CITY OF ALBUQUERQUE

August 15, 2008

Re: Target at Unser Town Crossing, Grading and Drainage Plan
Engineer's Stamp dated 7-15-08 (J10/D002G1)

DETENTION POND OUTLET STRUCTURE
N.T.S.

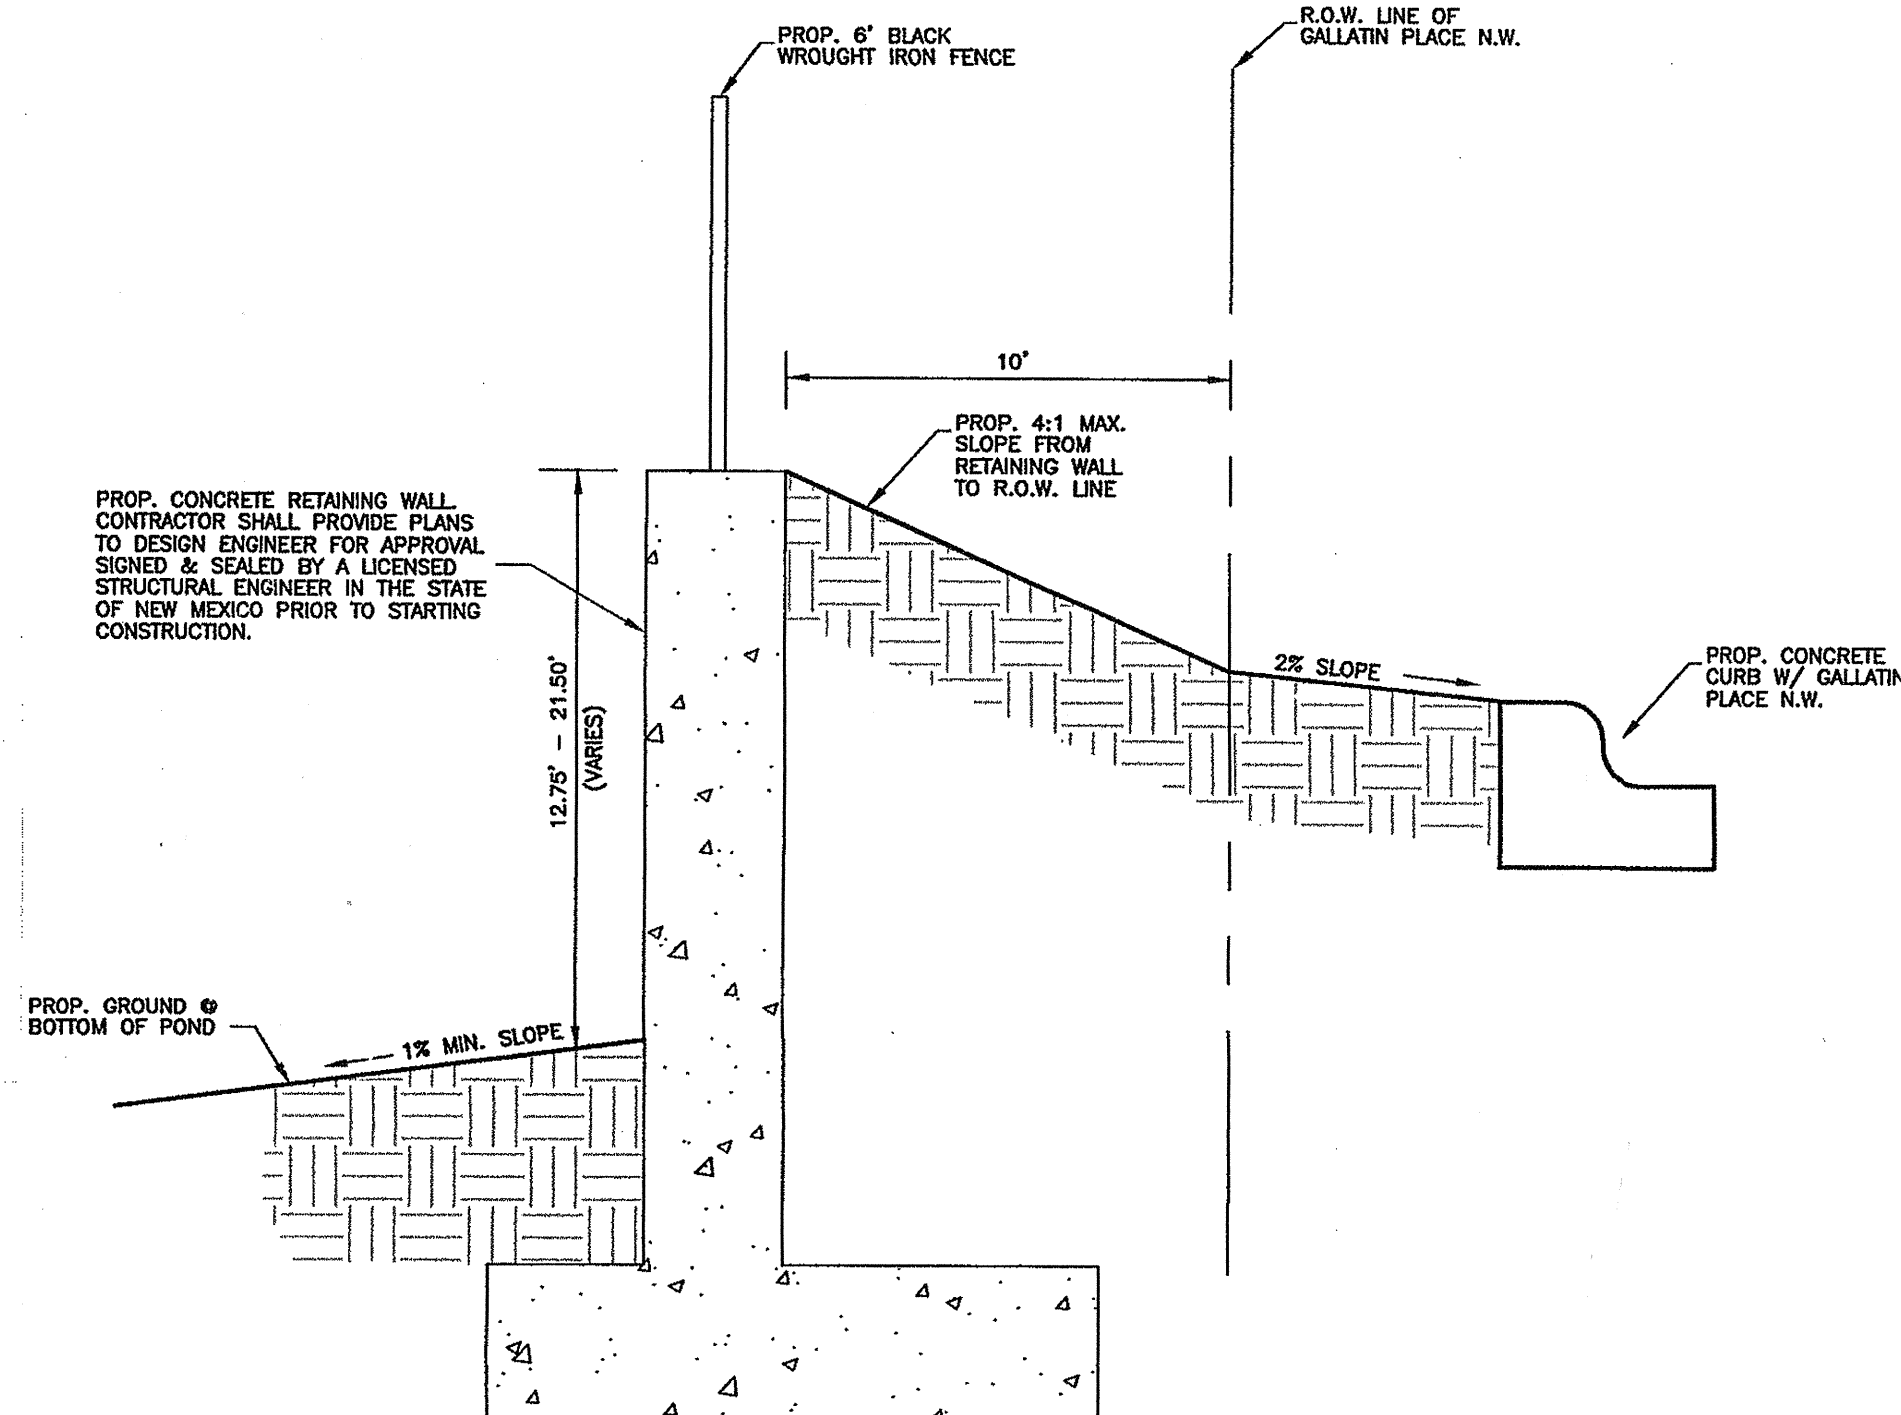
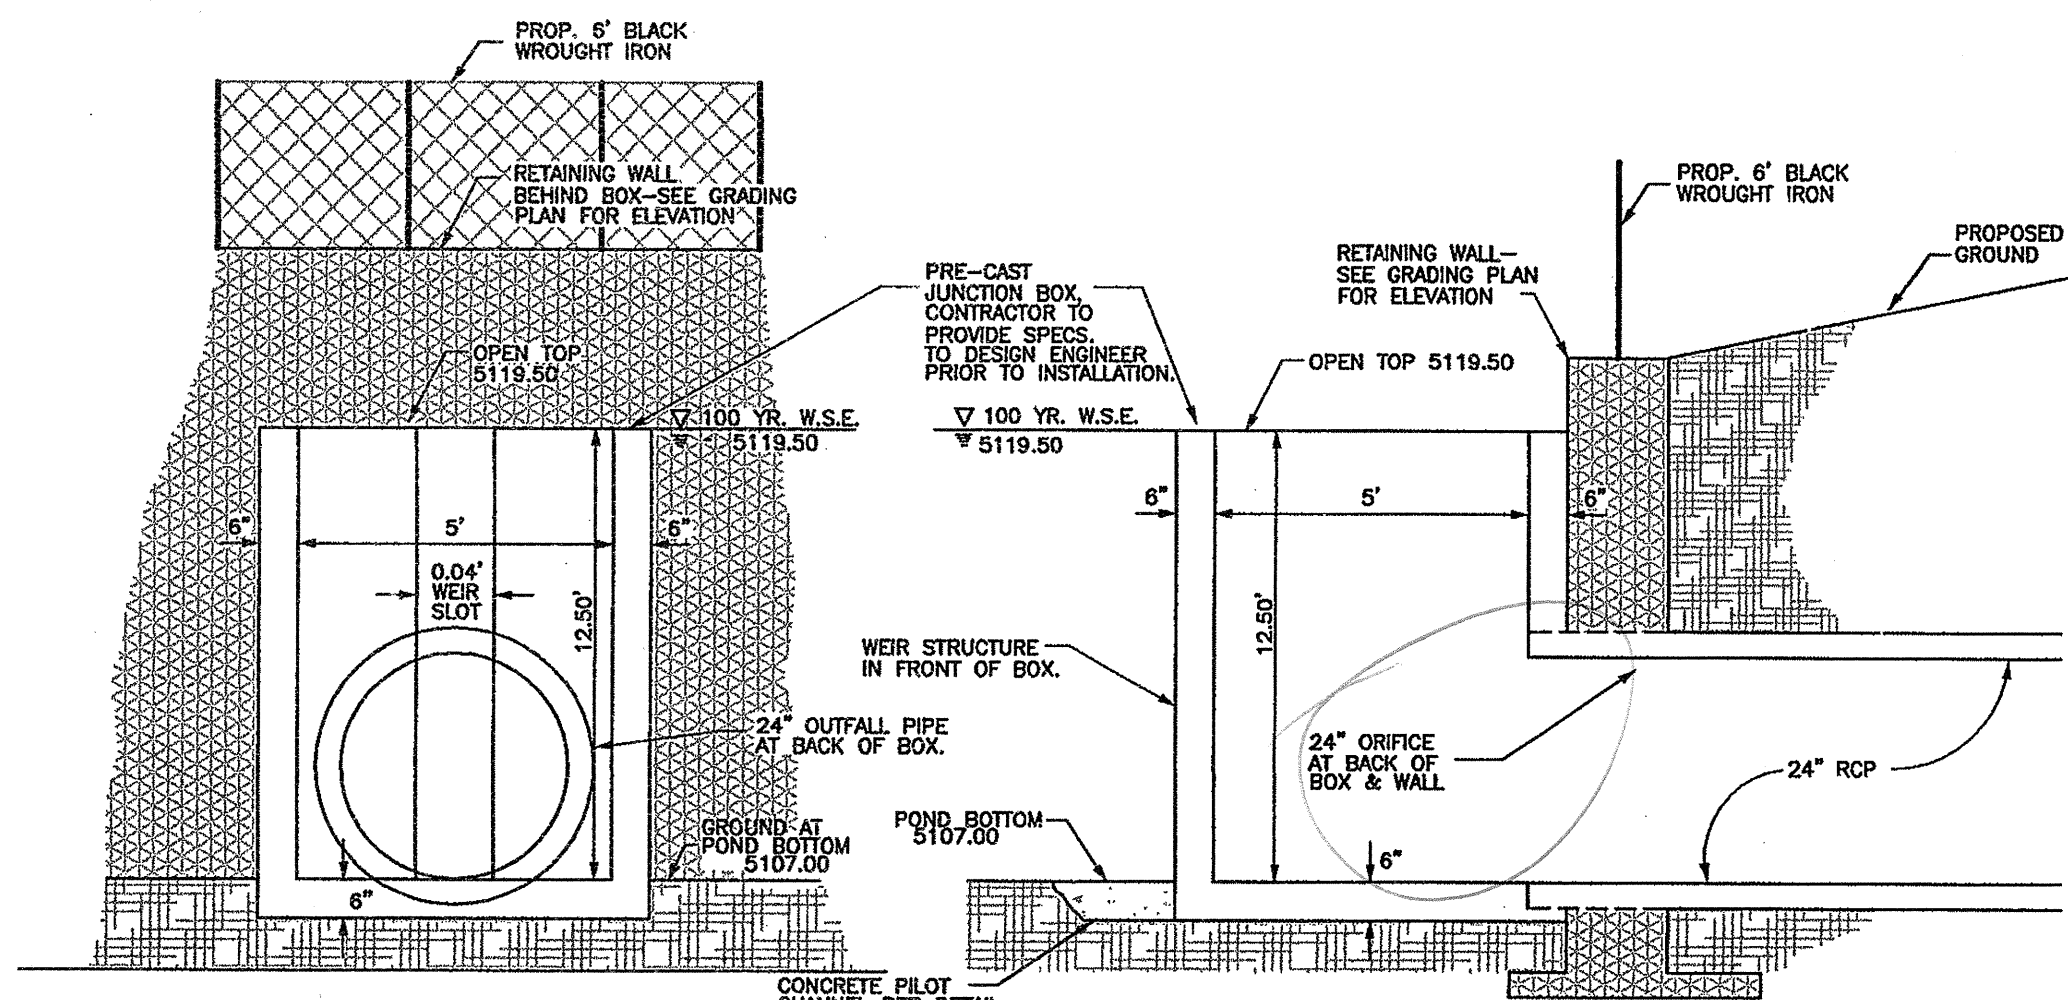
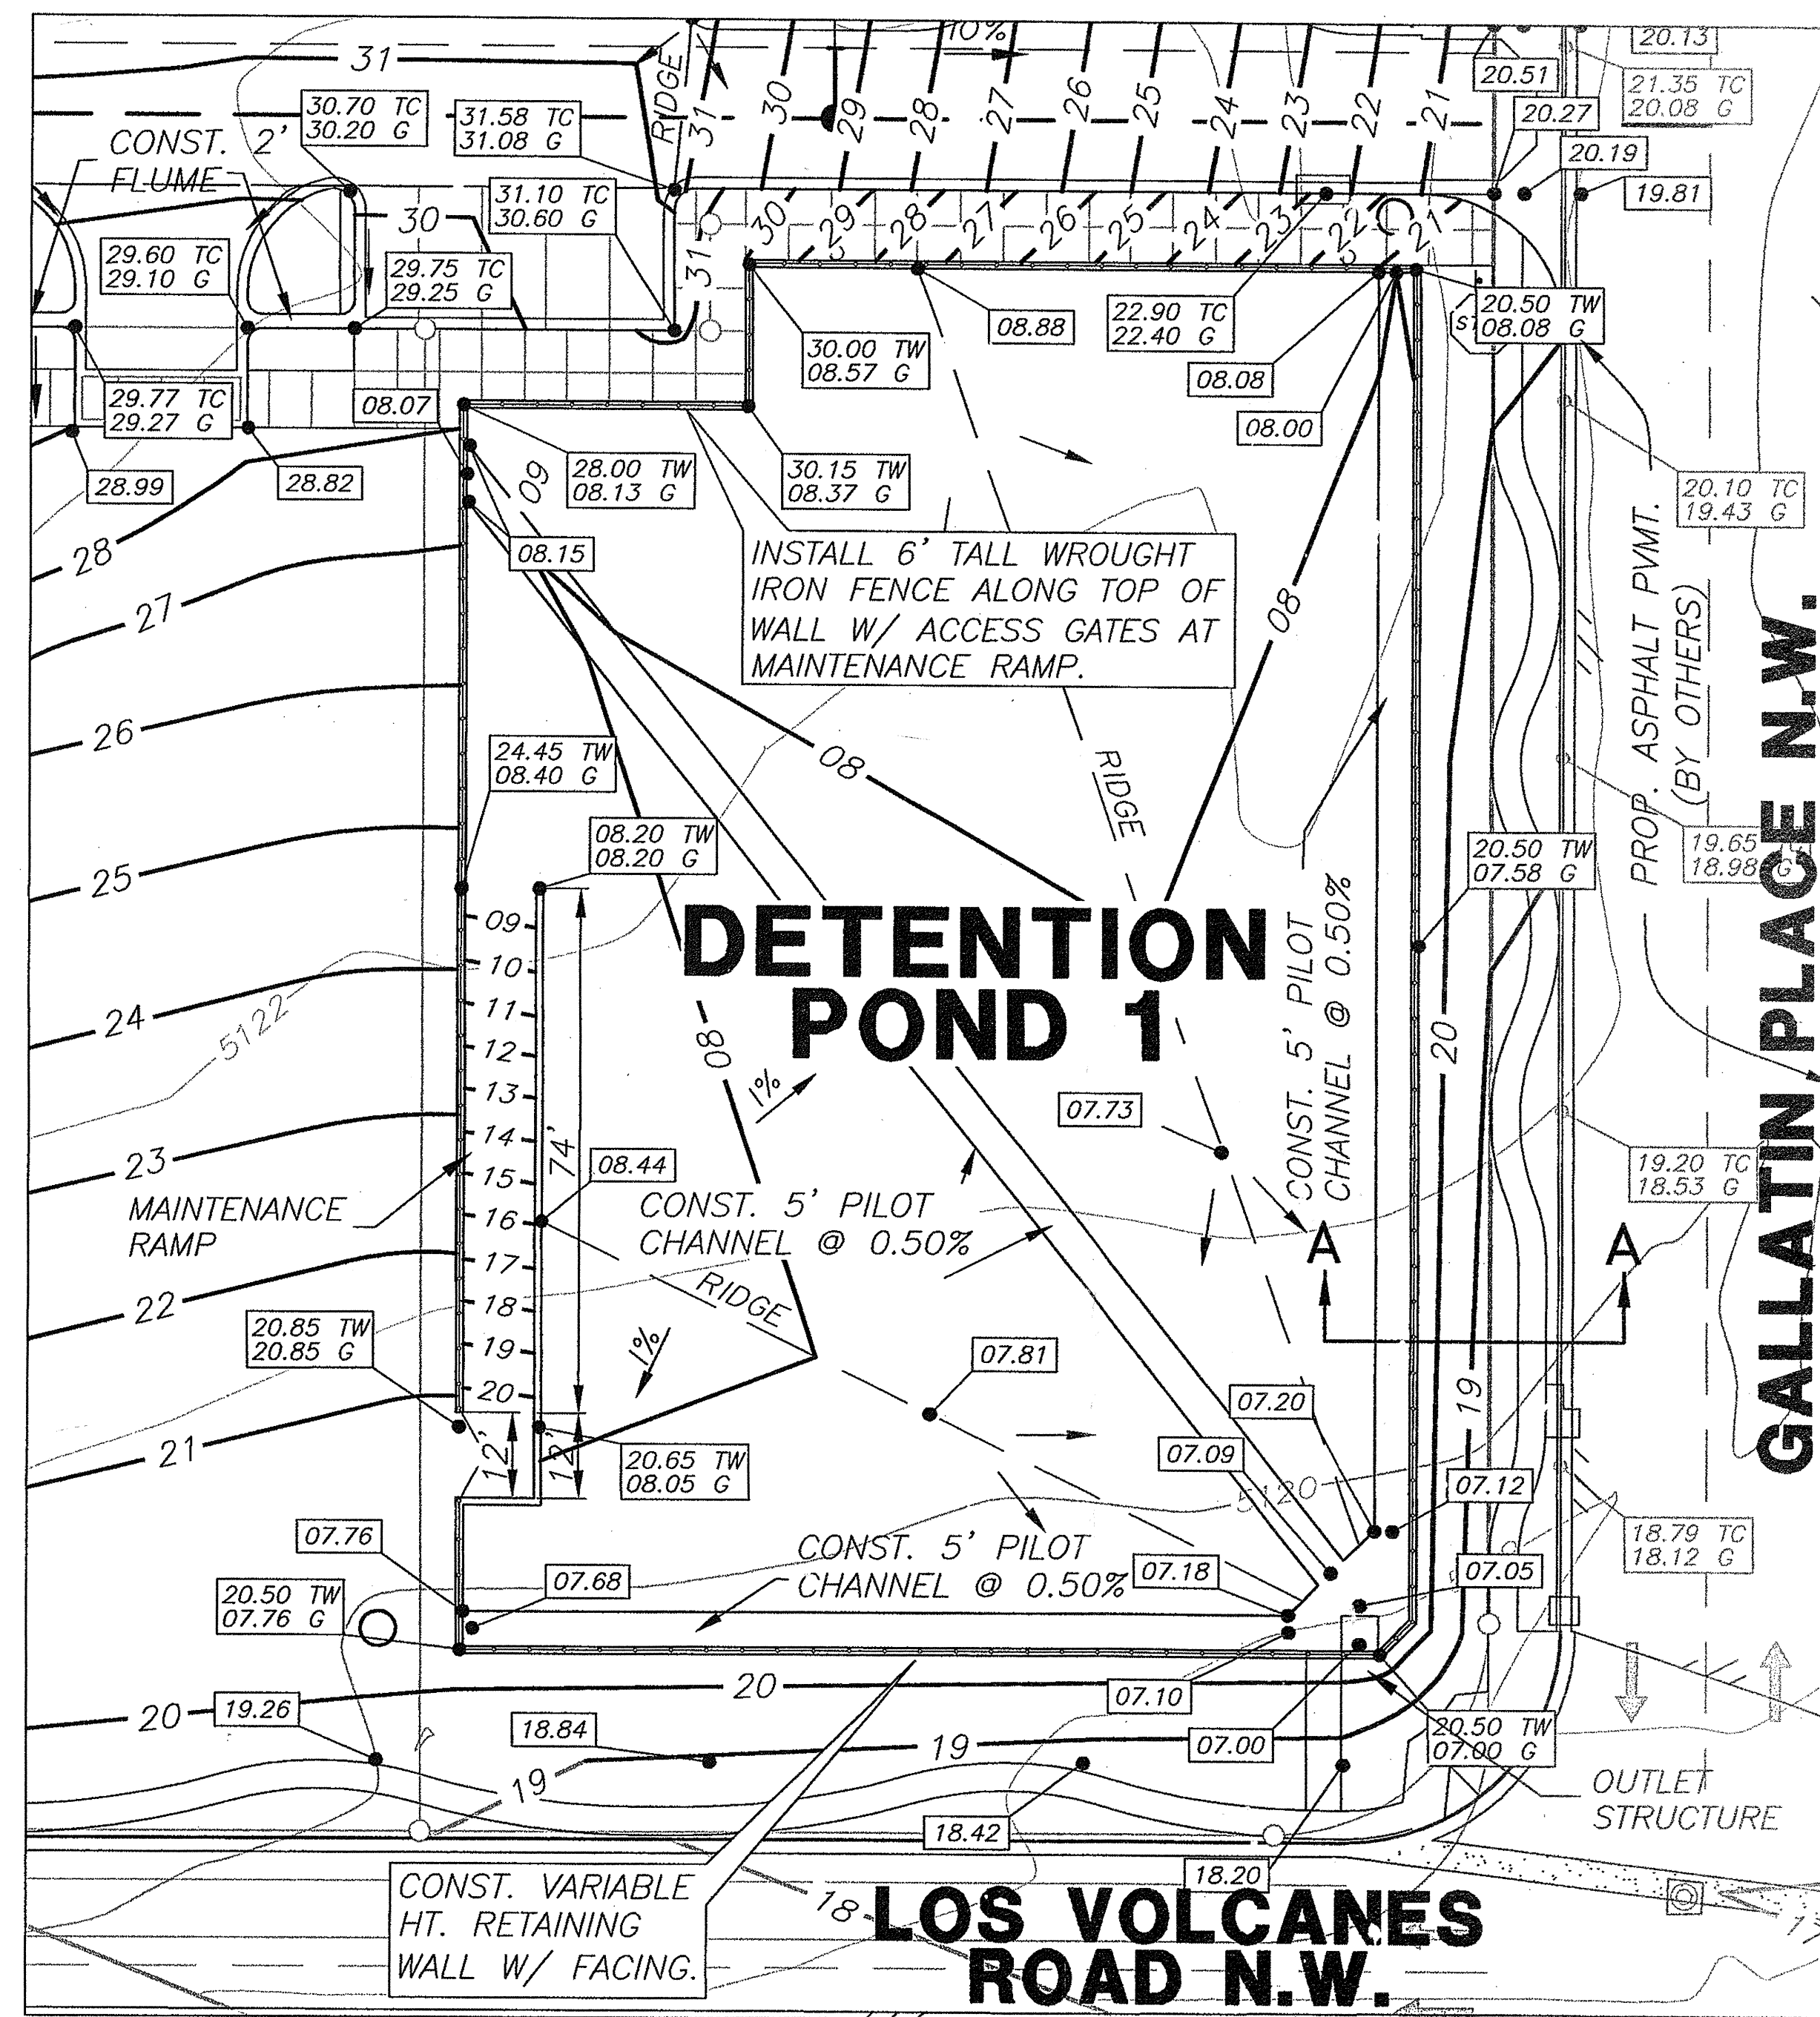
- Some clarification is required at your pond outlets. The weir in front of the pipe should be modeled as an orifice. Are the 24" and 18" orifices just the pipe? If so, they don't need a build note. The "open top" of the overflow protection should have a trash rack.
